PLOT PLAN

460 GARDEN PARK AVE. CALHAN, CO 80808
MAYBERRY, COLORADO SPRINGS FILING NO. 1
A PORTION OF SECTION 14 & 15, T 14S, R 63 W, 6TH PM
COLORADO SPRINGS, EL PASO COUNTY, COLORADO

DISAPPROVED
Plan Review

# PLOT PLAN

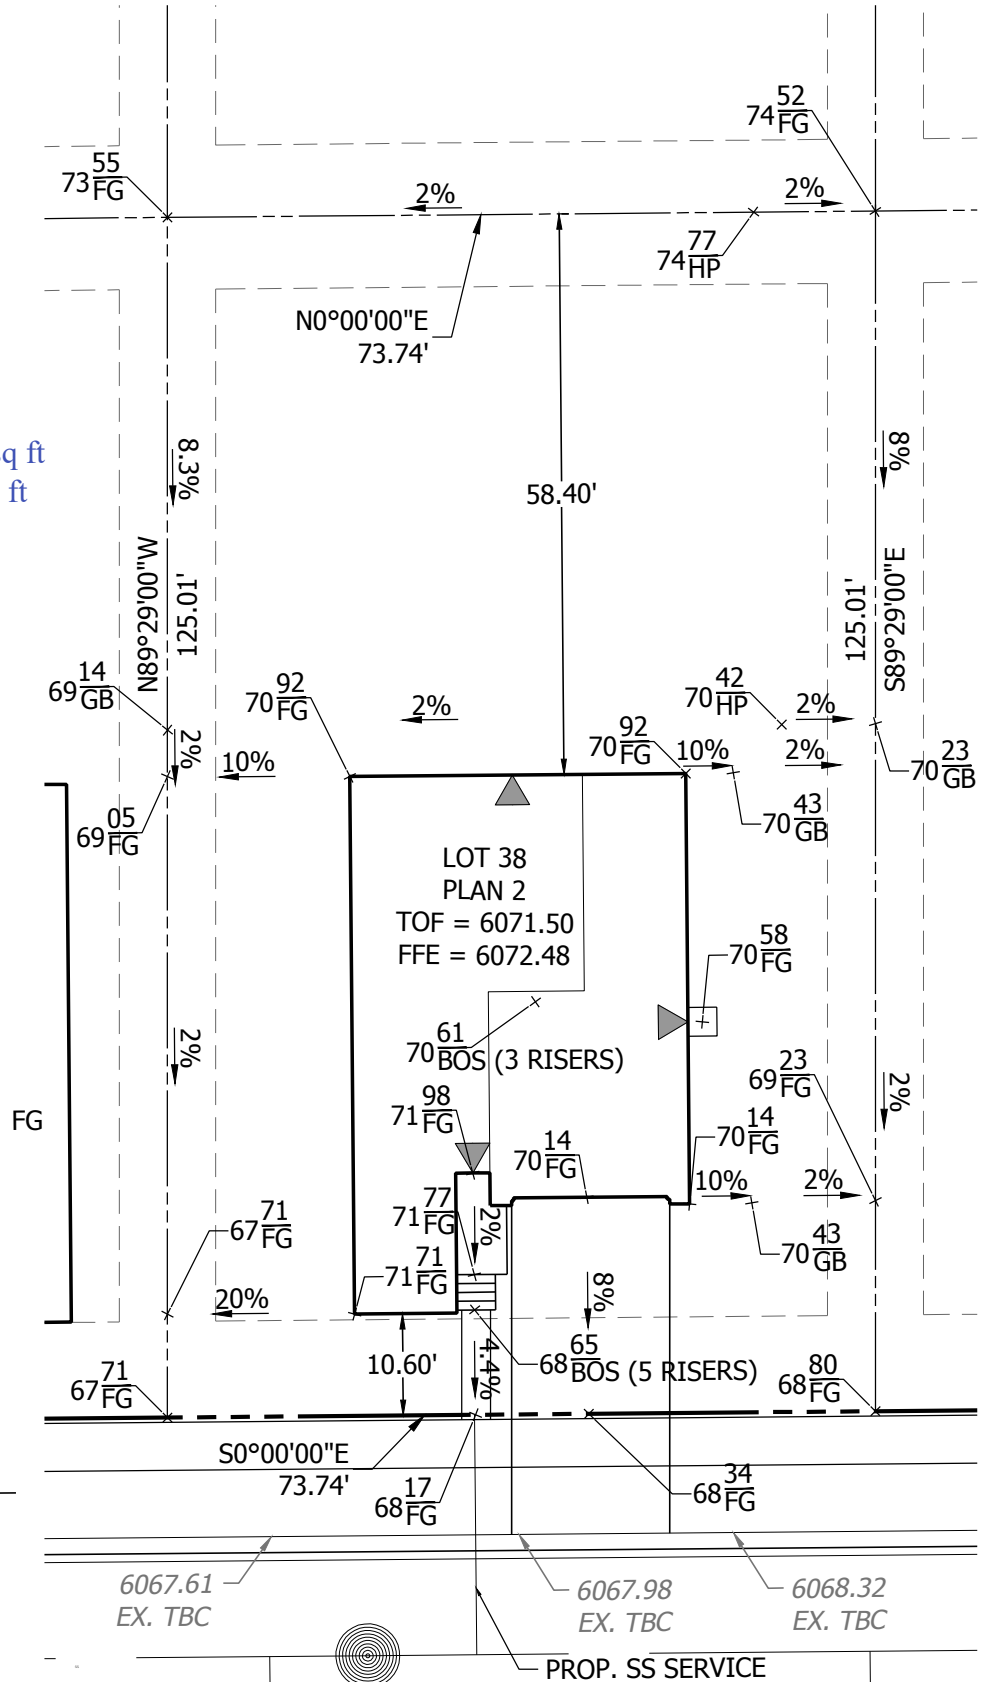
Provide site data (lot size,
residence size, % lot
coverage and average
building height) on all site
plans.
